MMC: FW: Shaws TCP (CMP)

Hi Nell – The following are some initial comments on the Construction Management Plans. I will likely have additional questions after receiving responses to these comments.

Maine Medical Center Site Enabling PH2		Phase 1 Work Zone Traffic Control Plan		FIGURE <b>1A</b>
Shaw Brothers Construction, Inc. 341 Mosher Road, P.O. Box 69 Gorham, Maine 04038 (207) 839-2552			DRAWN: M.E.    DATE: 4/24/19	
		DESIGNED: -    SCALE: 1"=100'		
		CHECKED: -    FILE: -		
		FILE LOC: -

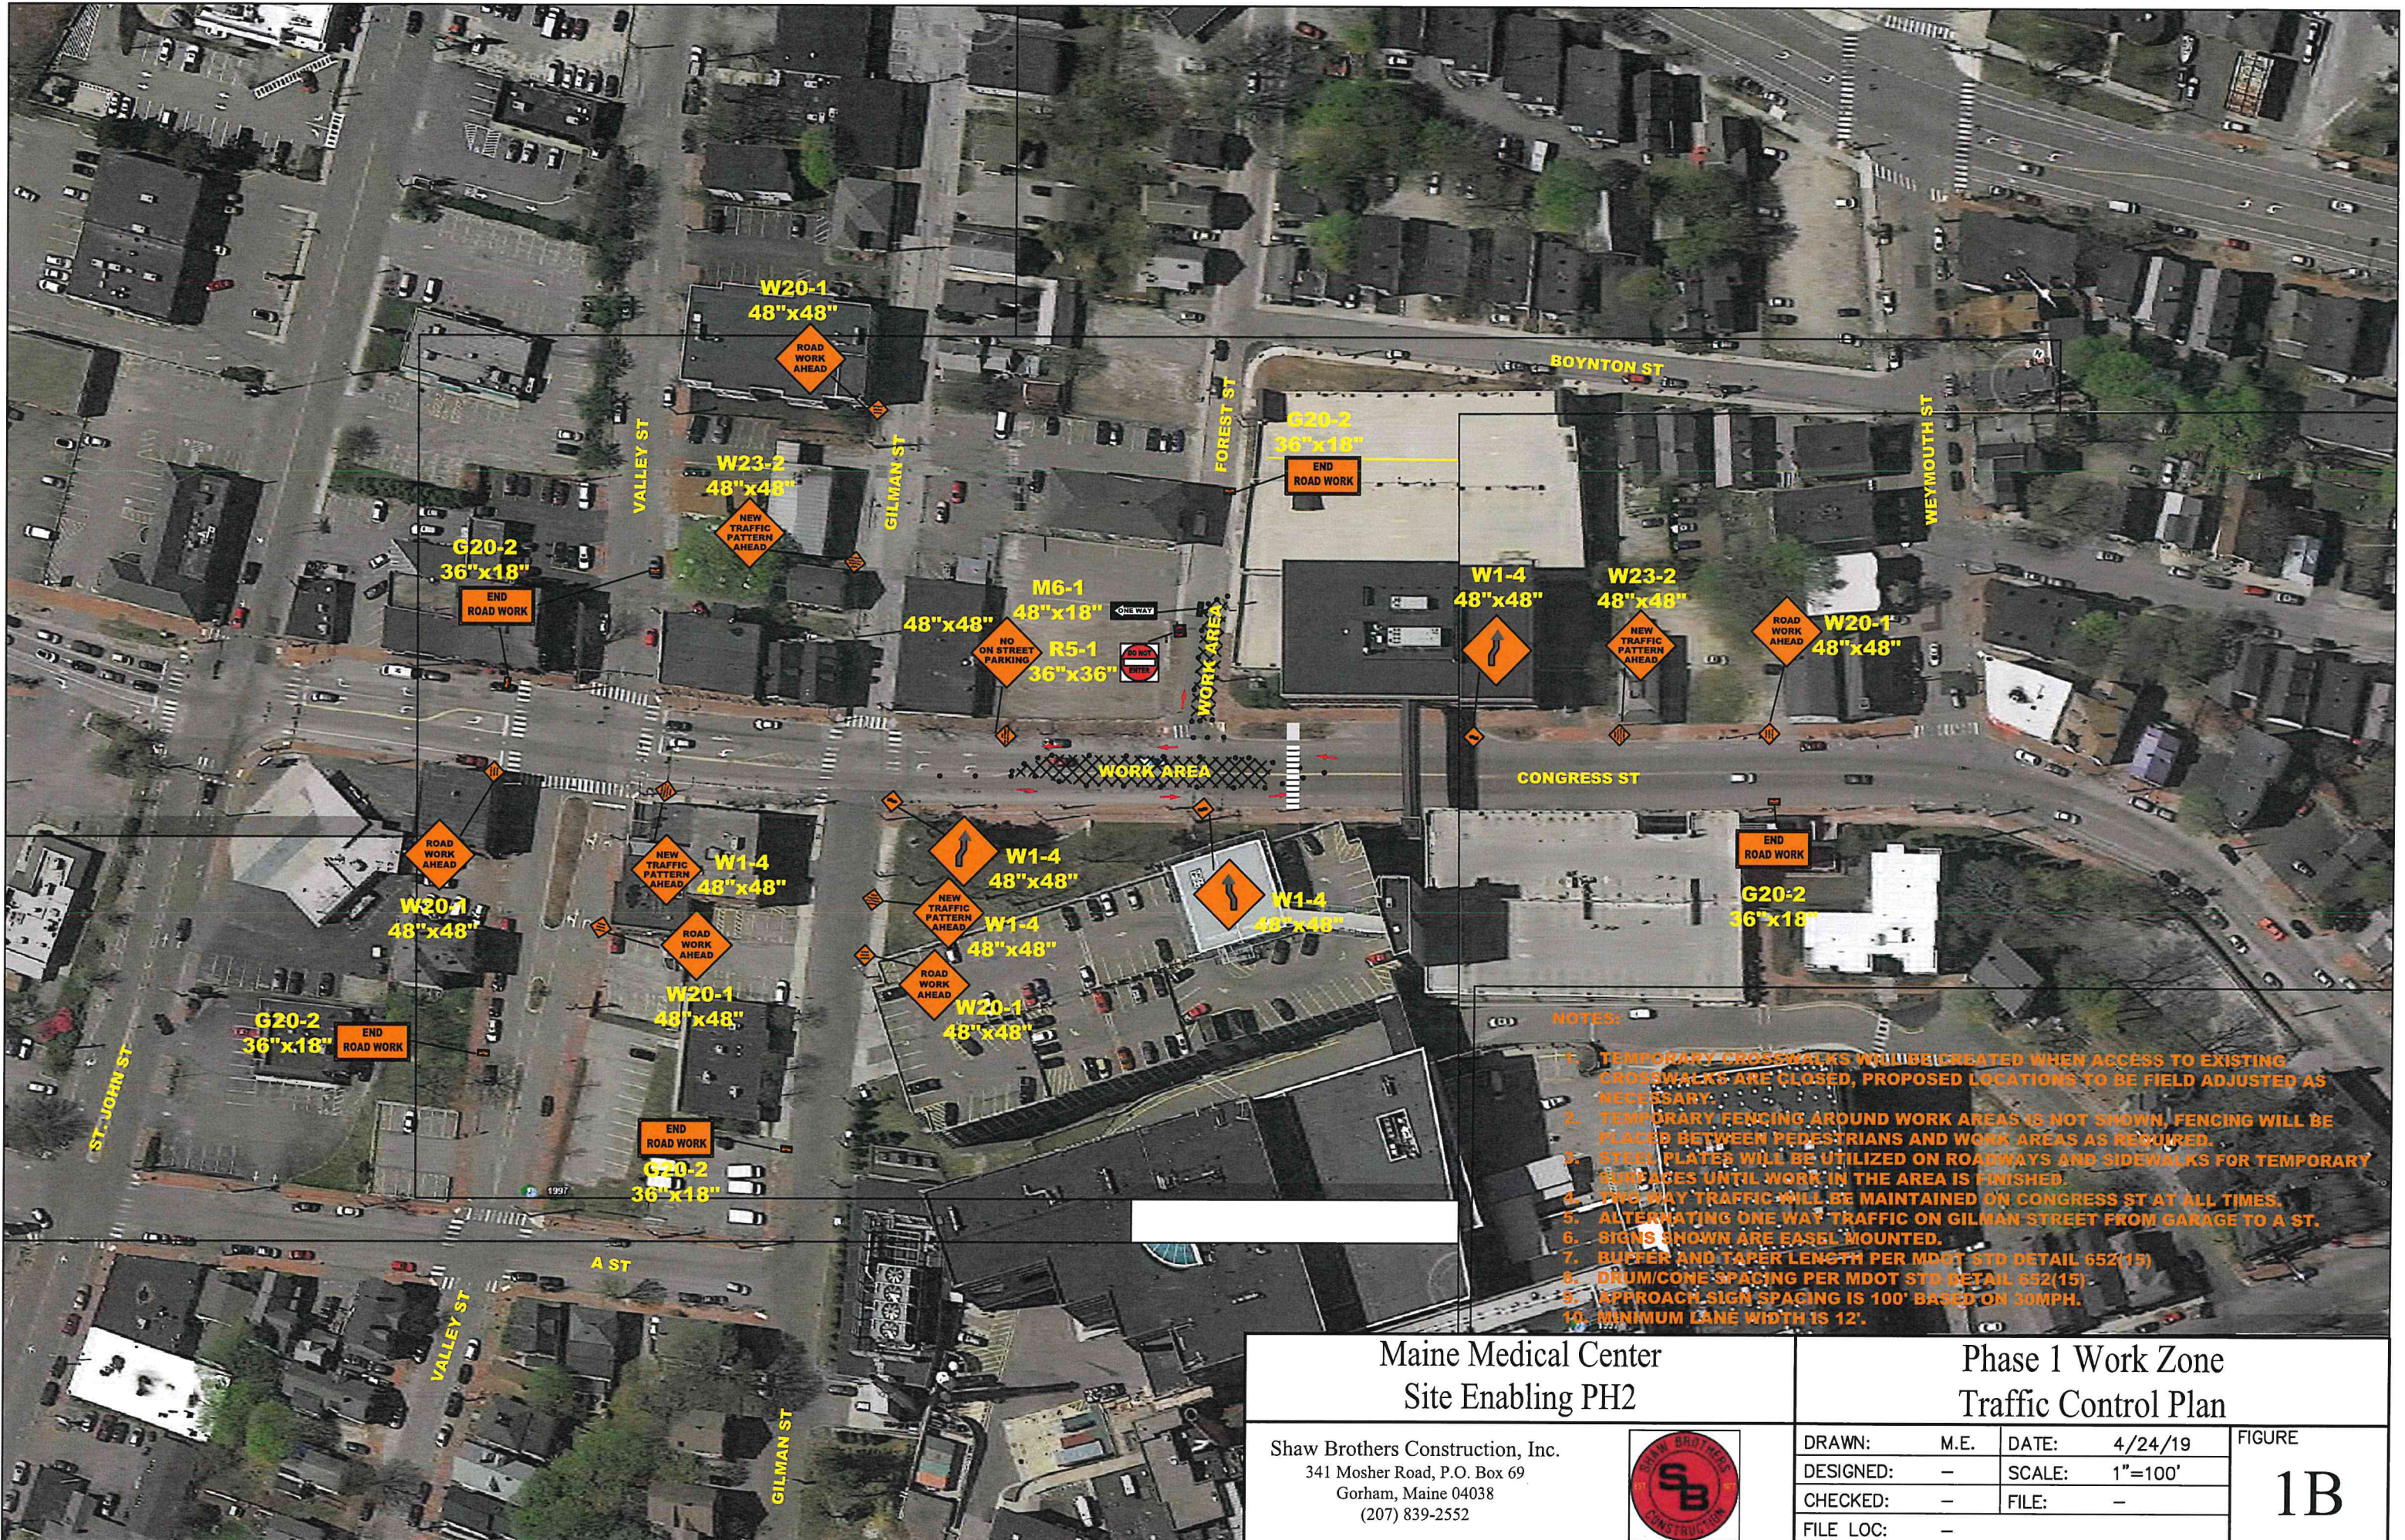
- Provide taper calculations for lane shifts (for all phases).

Maine Medical Center Site Enabling PH2		Phase 1 Work Zone Traffic Control Plan		FIGURE <b>1B</b>		
Shaw Brothers Construction, Inc. 341 Mosher Road, P.O. Box 69 Gorham, Maine 04038 (207) 839-2552		DRAWN:	M.E.		DATE:	4/24/19
		DESIGNED:	-		SCALE:	1"=100'
		CHECKED:	-		FILE:	-
		FILE LOC:	-

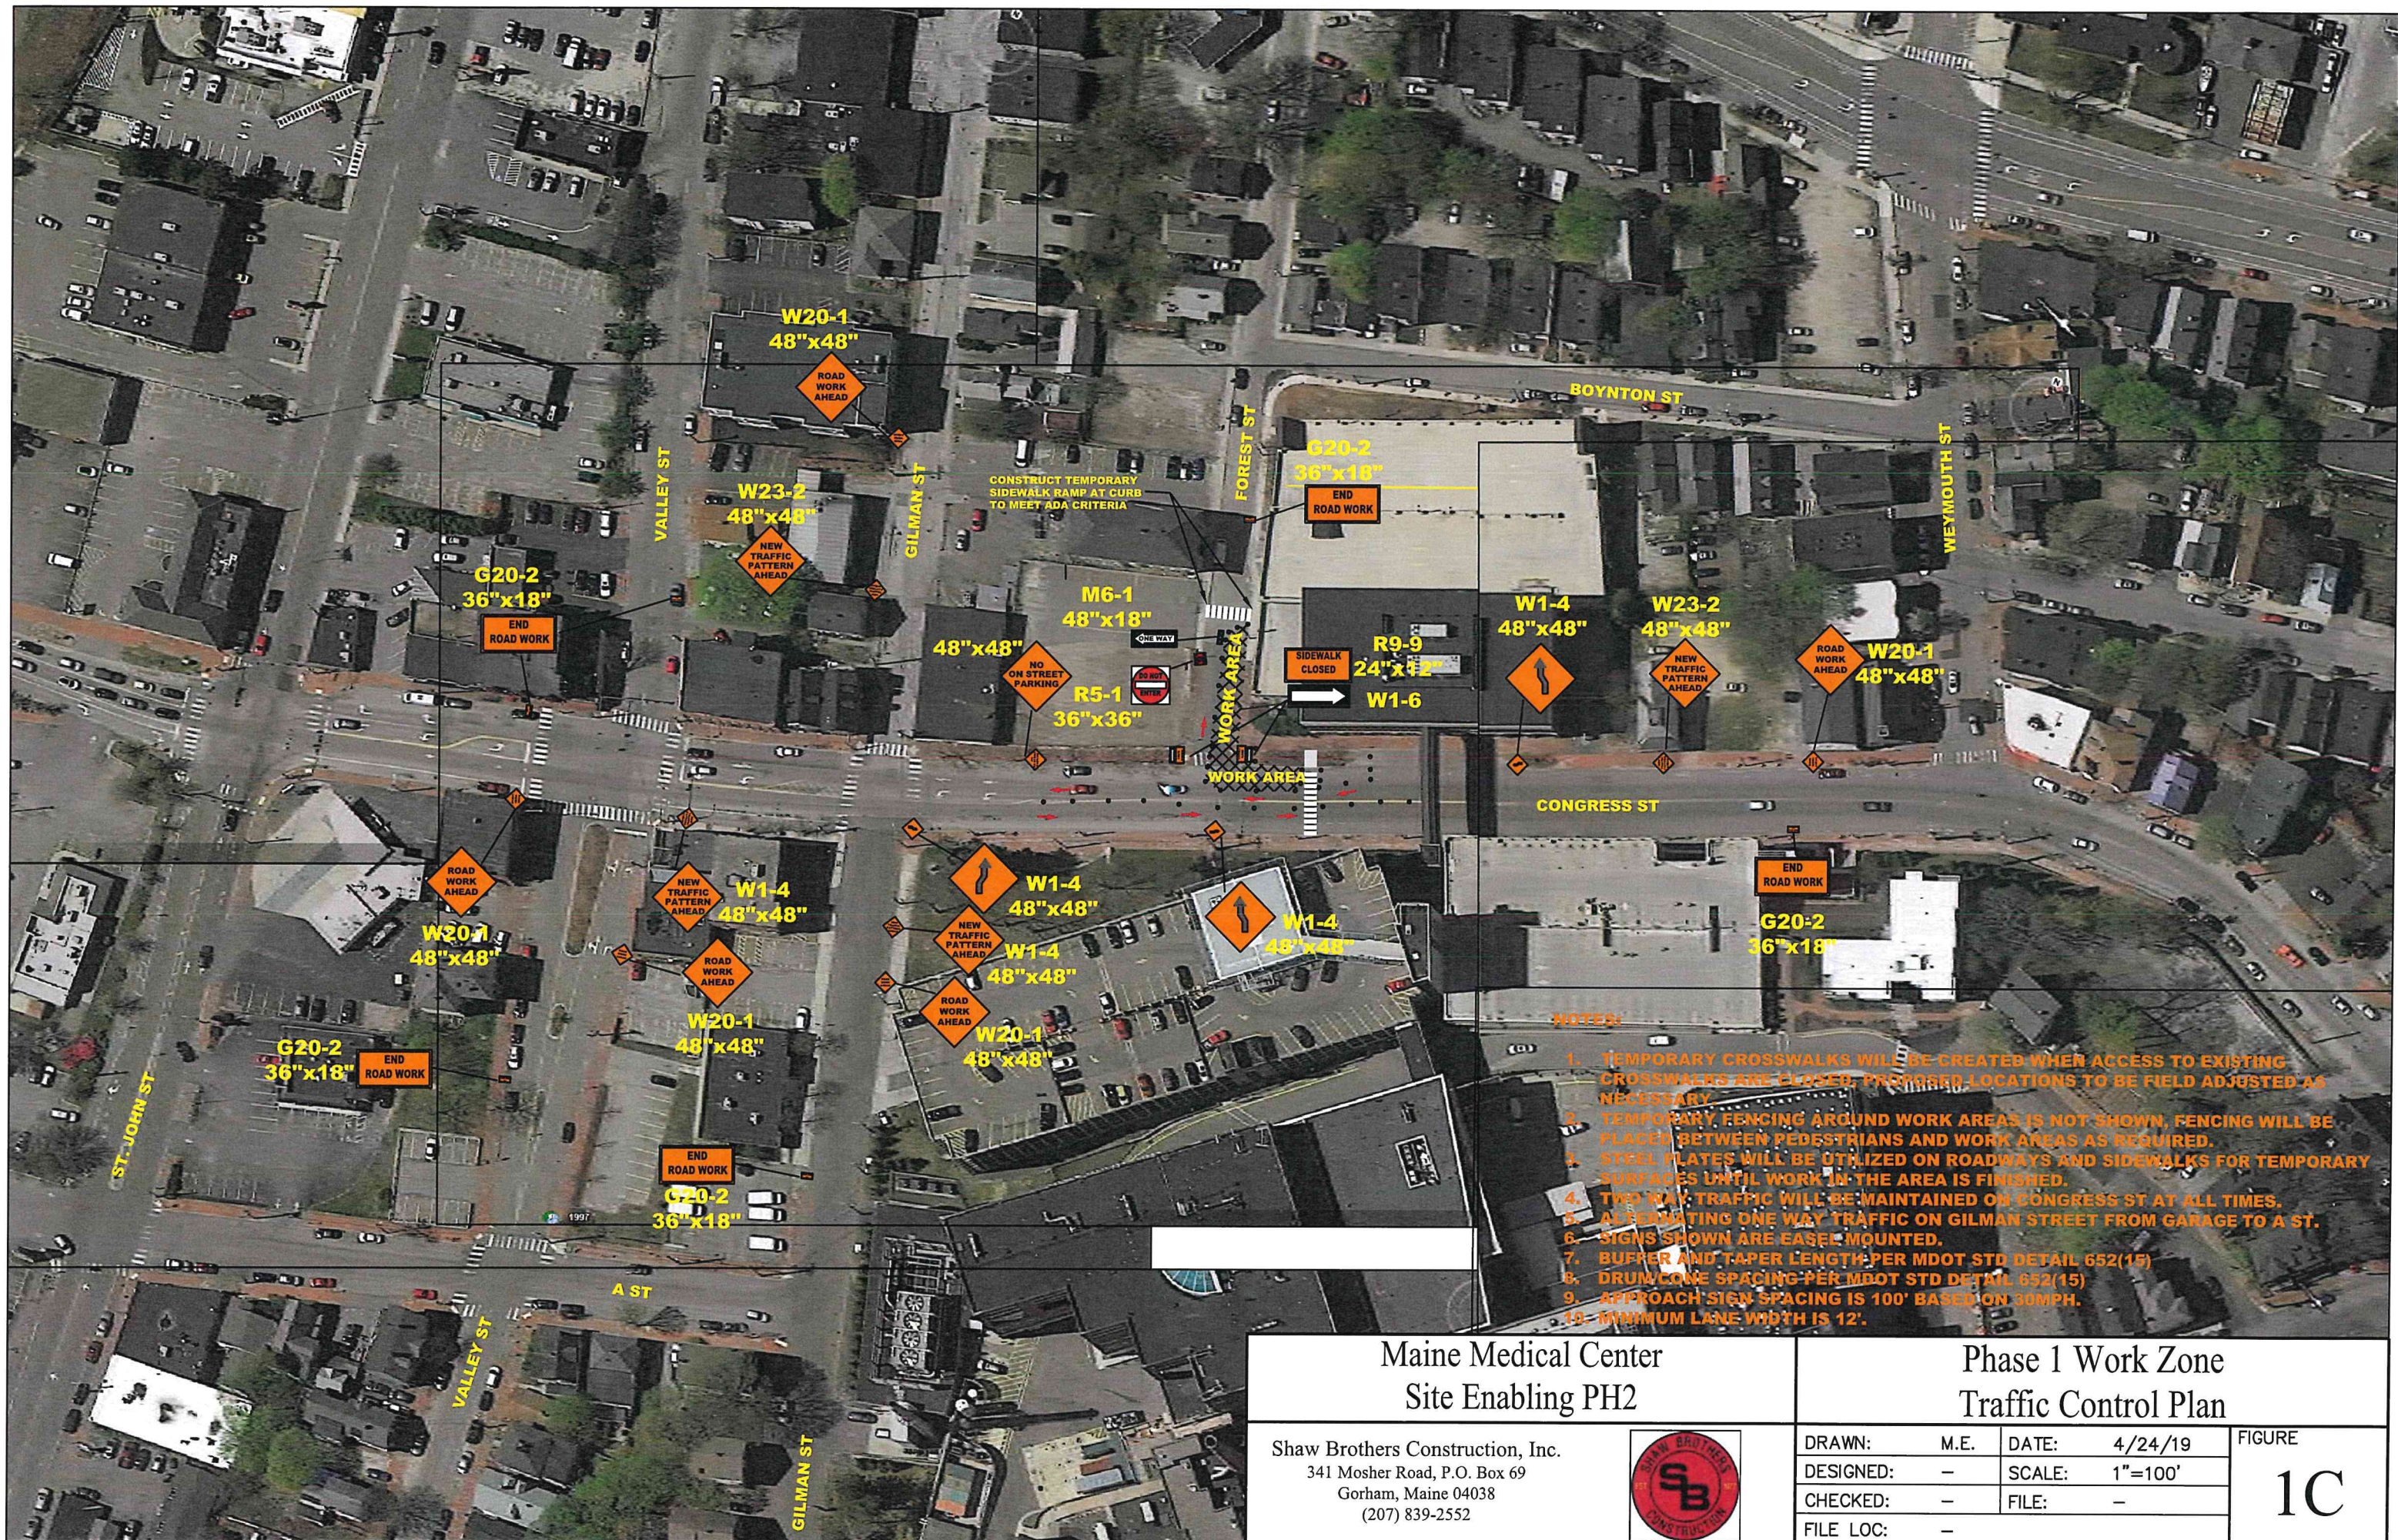
- Conflicting signs exiting garage on Forest should be addressed.
- Could a few of the on-street parking spaces be returned for use in front of Salvage BBQ.

Maine Medical Center Site Enabling PH2		Phase 1 Work Zone Traffic Control Plan		FIGURE <b>1C</b>		
Shaw Brothers Construction, Inc. 341 Mosher Road, P.O. Box 69 Gorham, Maine 04038 (207) 839-2552		DRAWN:	M.E.		DATE:	4/24/19
		DESIGNED:	—		SCALE:	1"=100'
		CHECKED:	—		FILE:	—
		FILE LOC:	—

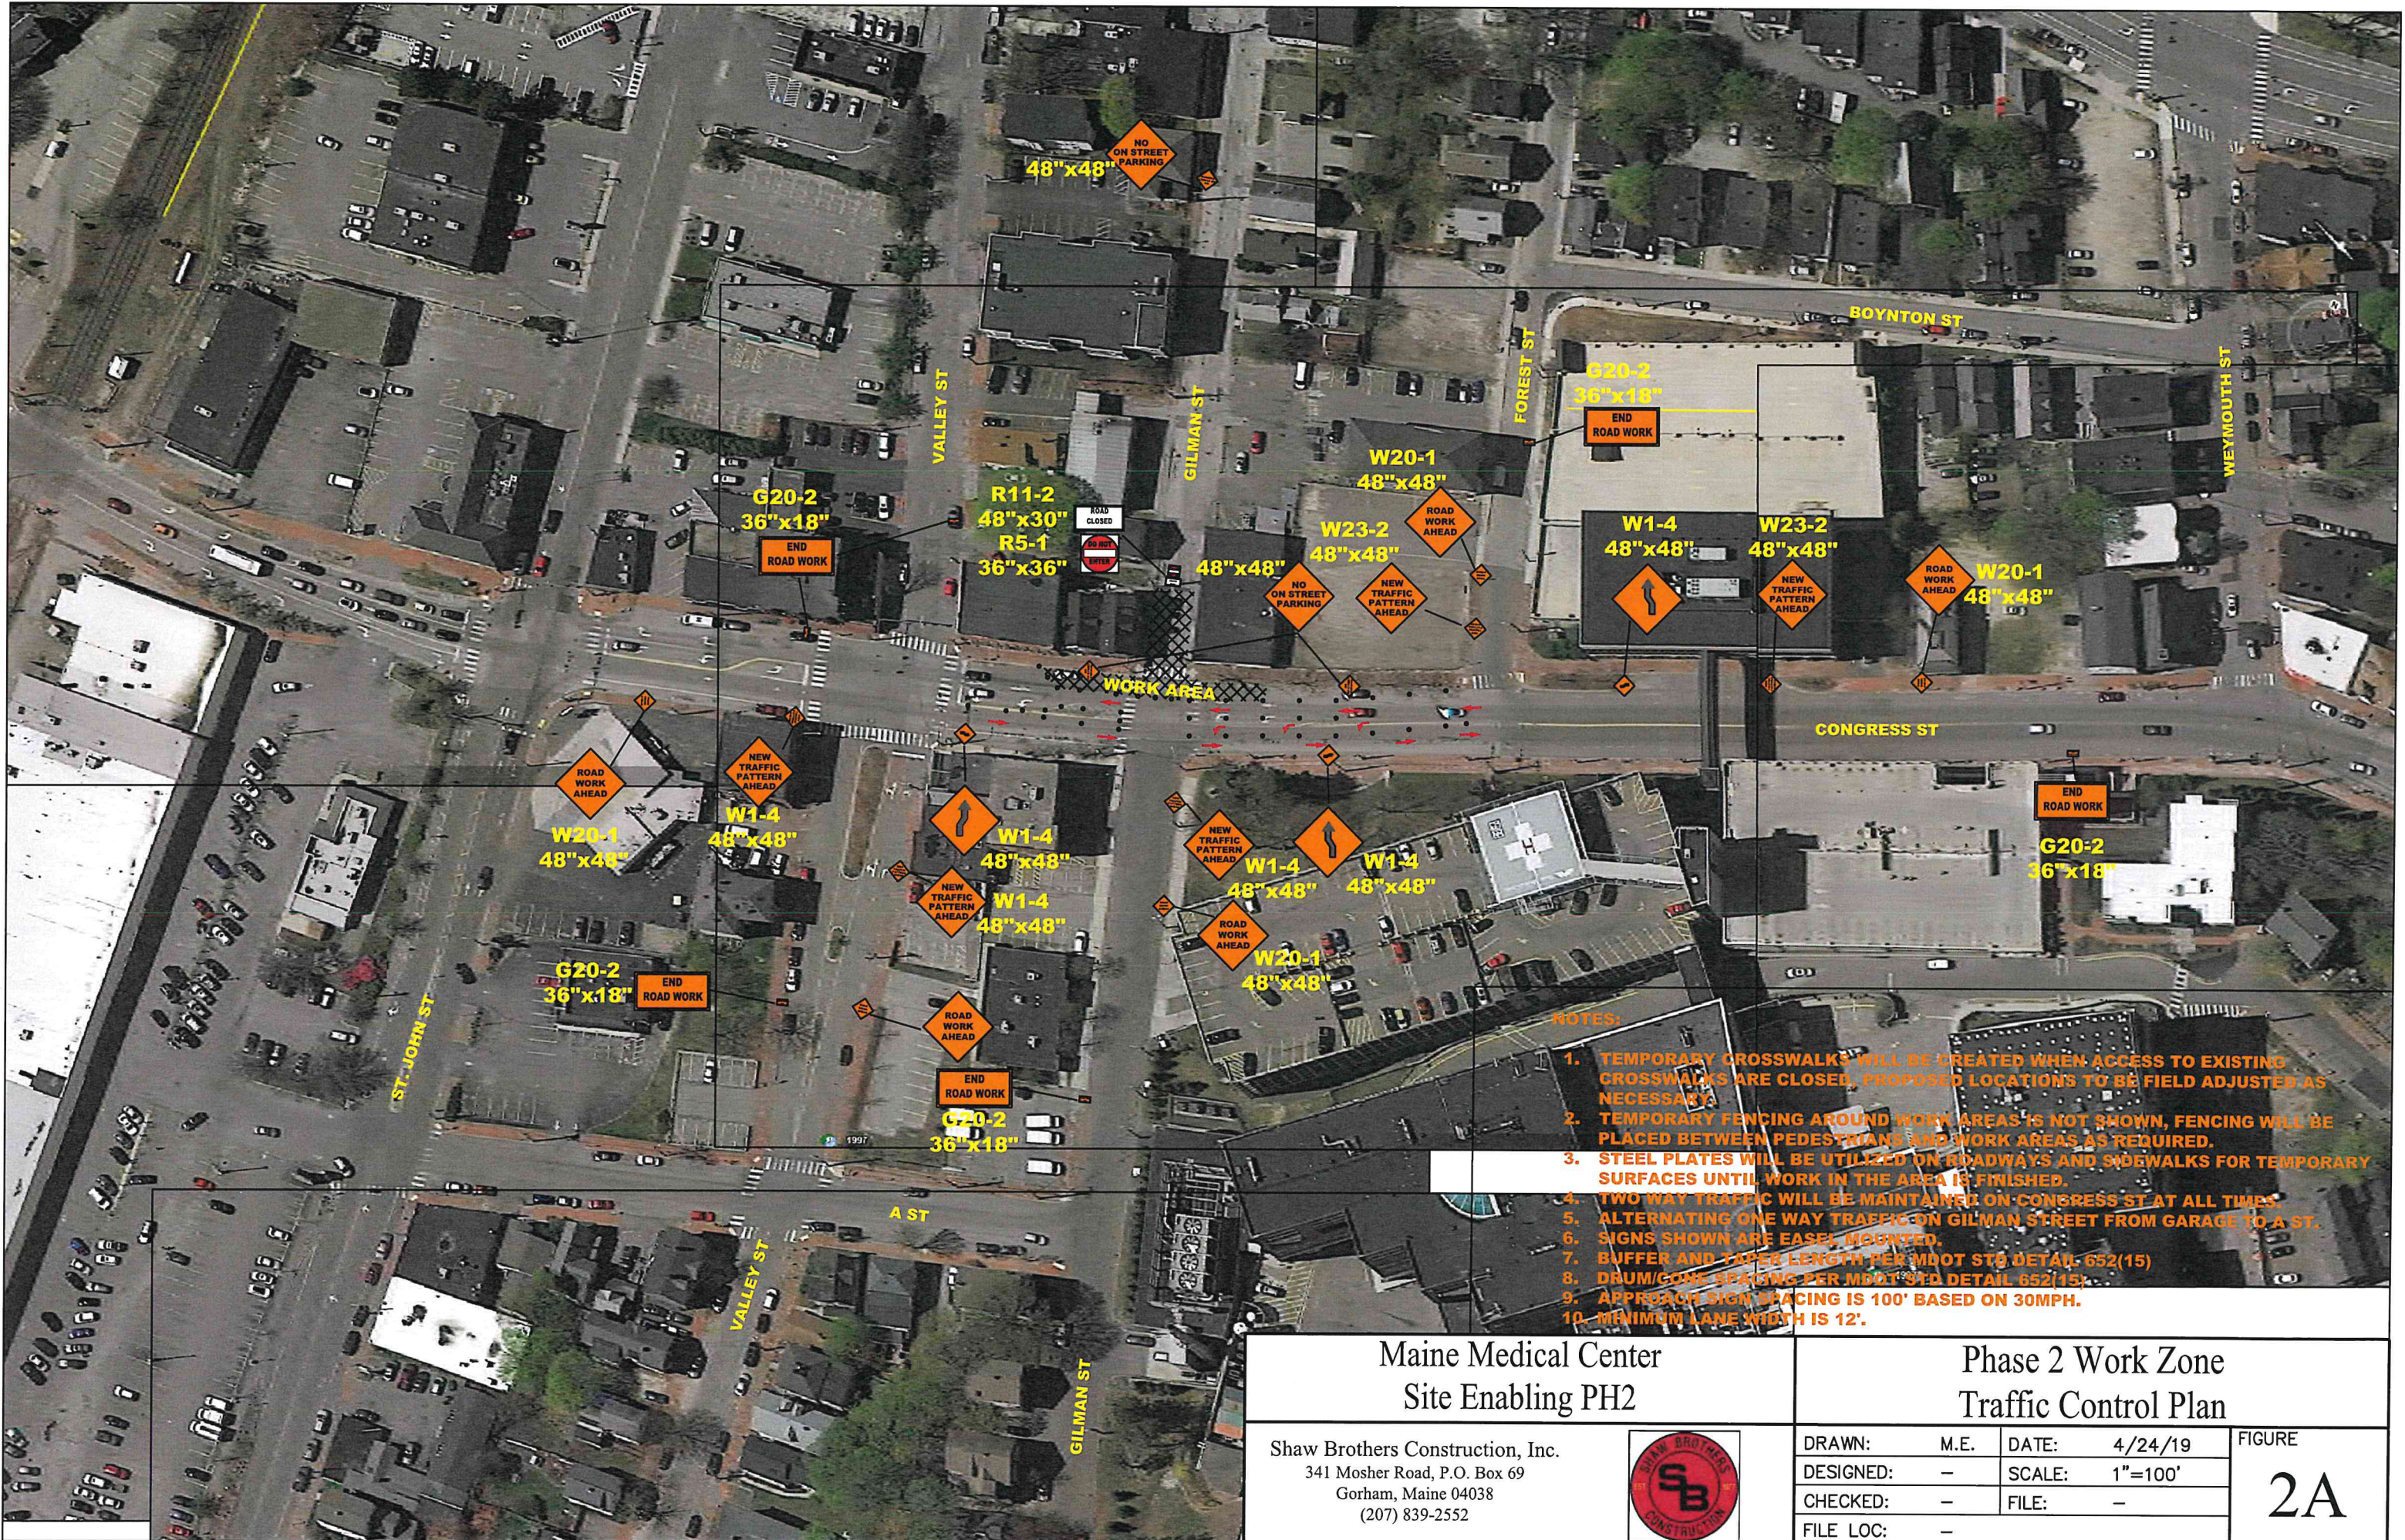
- Seems like some on-street parking could be allowed.
- Confirm ADA width requirements are met on Forest due to pole constraints.
